Re: Planning application for a 110 kilovolt electricity substation, approximately 7.5 kilometres of underground electricity line and all associated works at Moyvannan, Feamore, Lisbaun, Carrownolan, Carrowncloghan, Carrowkeeney, Ardmullan, Curraghboy, Gortnasythe, Derryglad, Eskerbaun, and Brideswell, County Roscommon

Ref. No. 321238

This report was prepared for Mr. Shane Butler of Cam, Brideswell, Athlone, Co. Roscommon. It examines the potential effects on Mr. Butler's residence and surrounding garden (the subject property) of the planning permission application to An Bord Pleanála (the Board) ABP-321328-24 alone and in combination with the granted permission ABP-313750-22.

Drawing Title:
FIGURE 6.6: JOINT BAY LOCATION 2

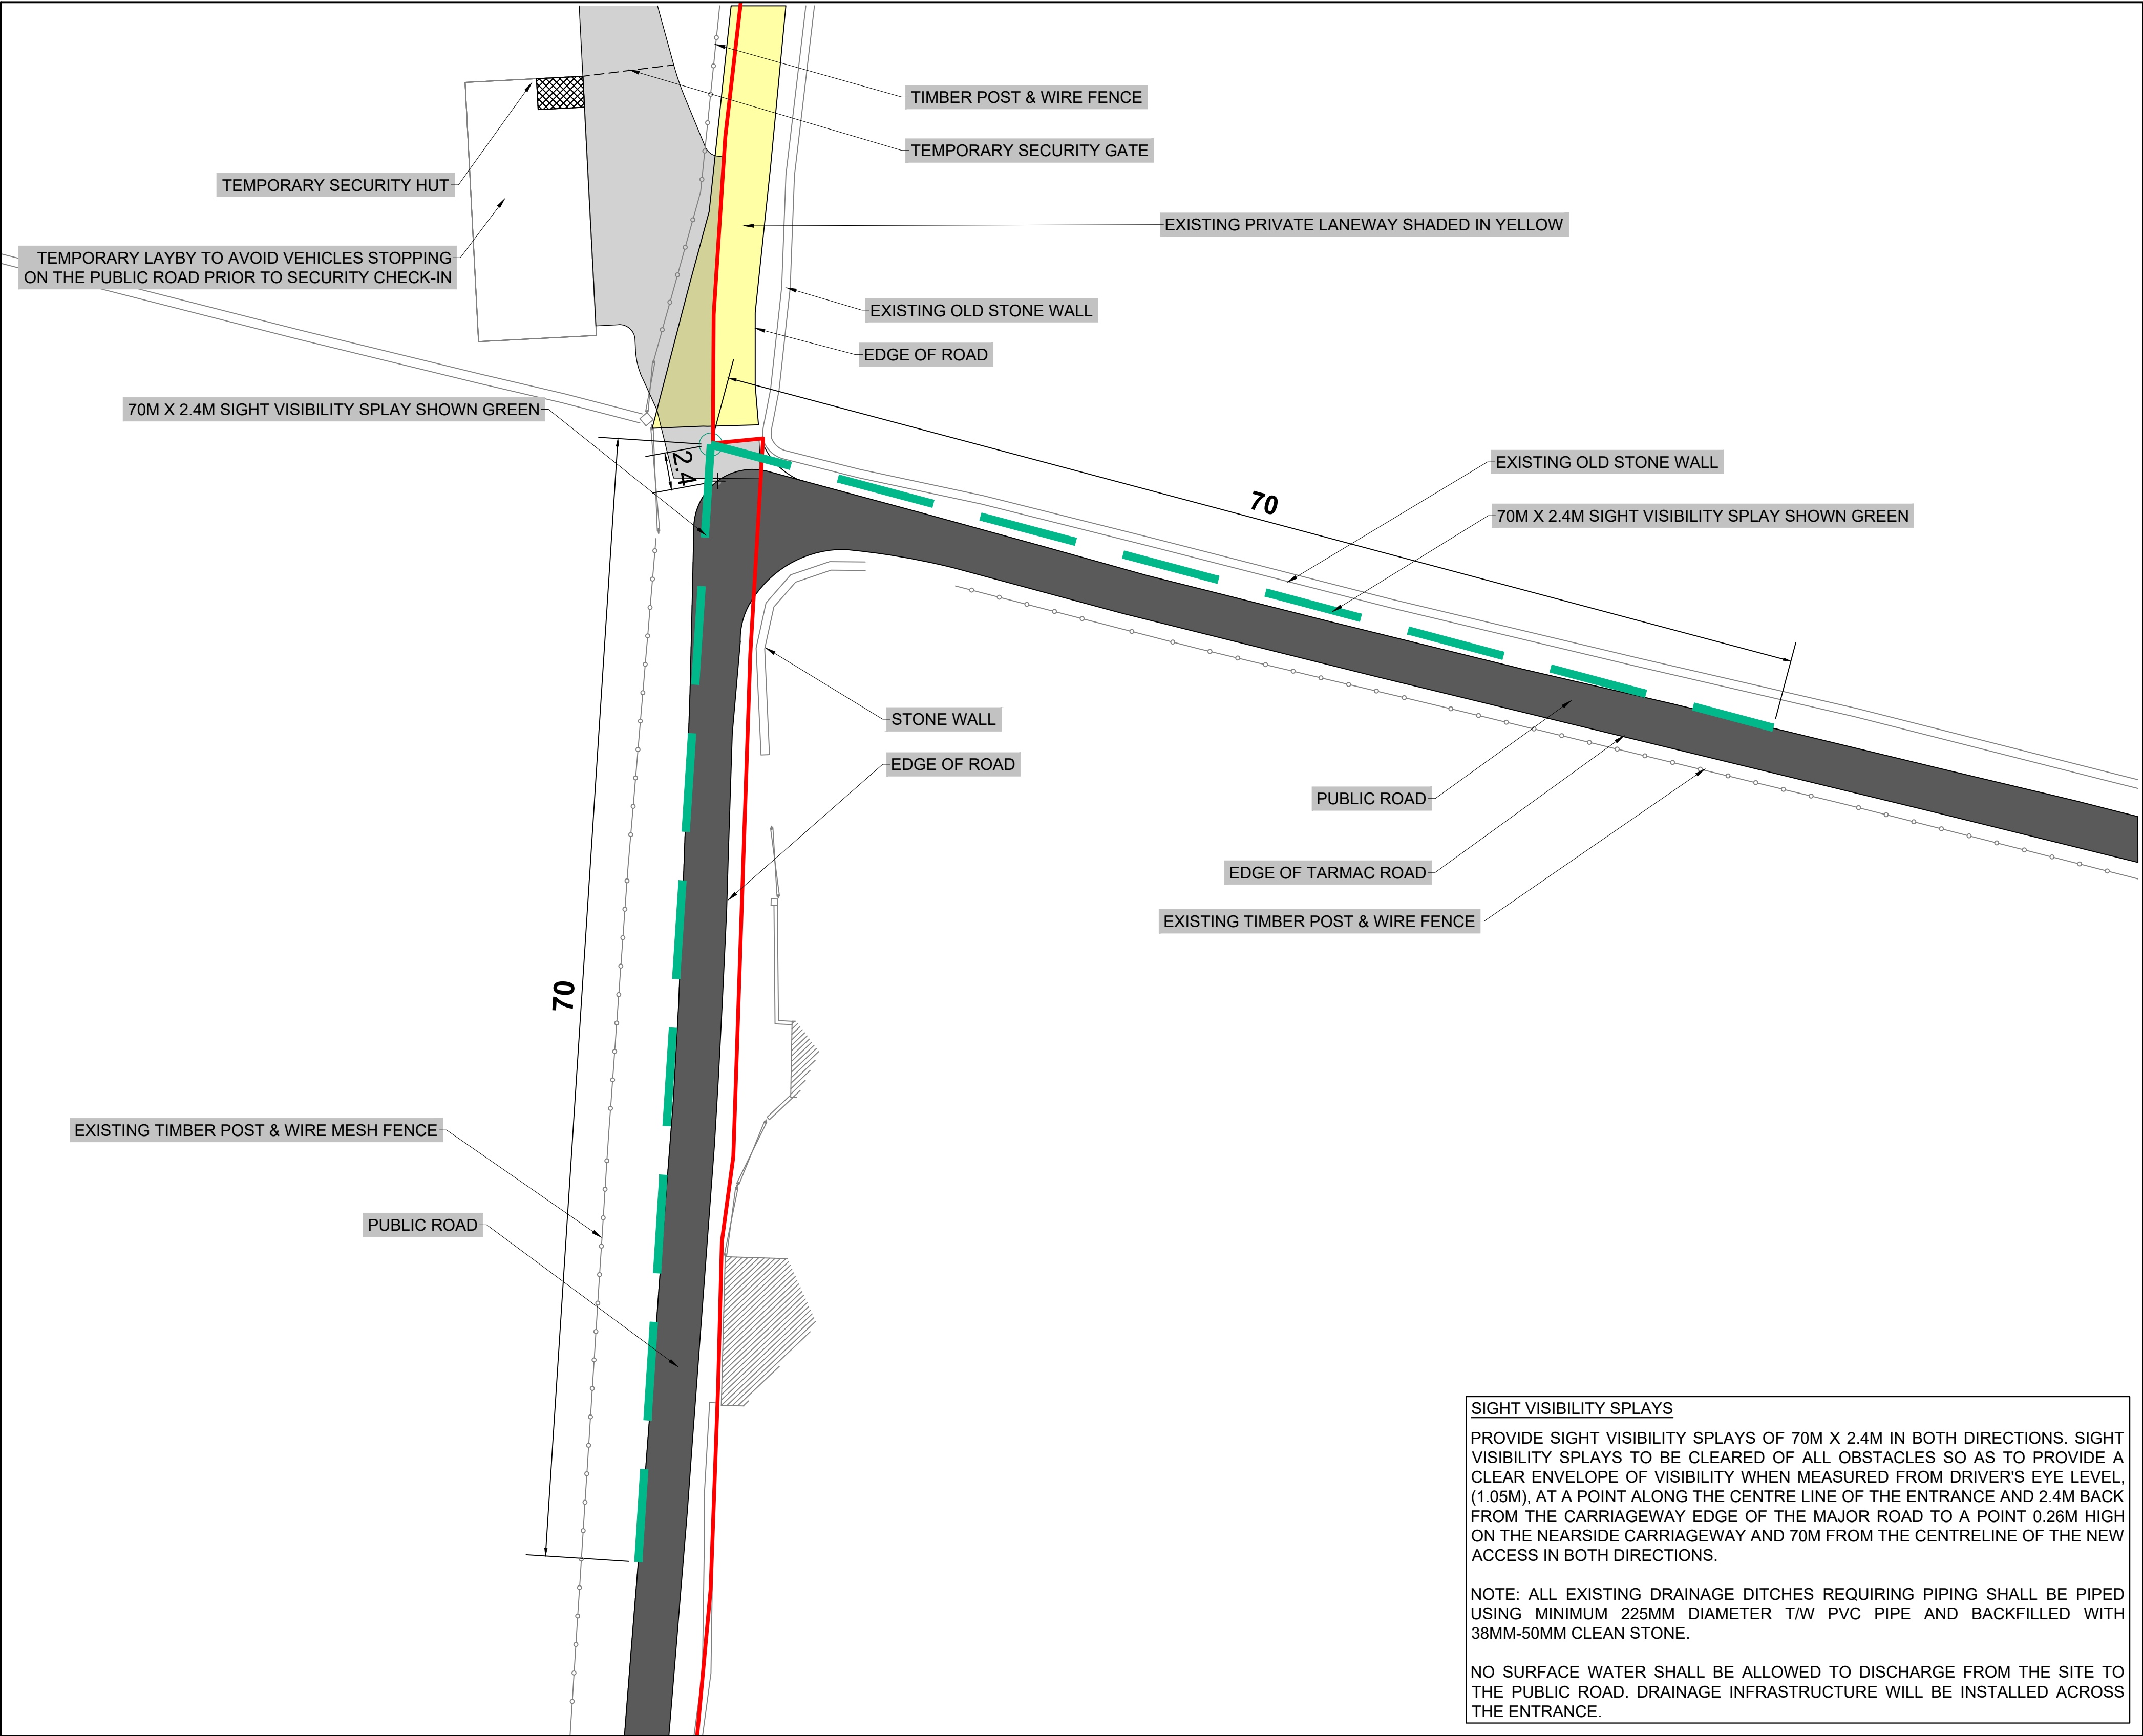
The local roads L2023,L7731,L2019 and the L7551 are not wide enough to accommodate the required joint boxes. The L2018 and the R363 may be able to accommodate the joint boxes but the installation will require extensive road closures. There is no location where these boxes can be accommodated in verges.

Mr. and Ms. Butler should contact the Roads section of RCC and request that they seek a safety audit from the applicant on the granted access point west of the subject property. They should also confirm that RCC are aware of the requirement of the joint bays at every 600 to 800m and request RCC's proposals for the long term maintenance of the R363 at the JB02 location adjacent to the subject property.
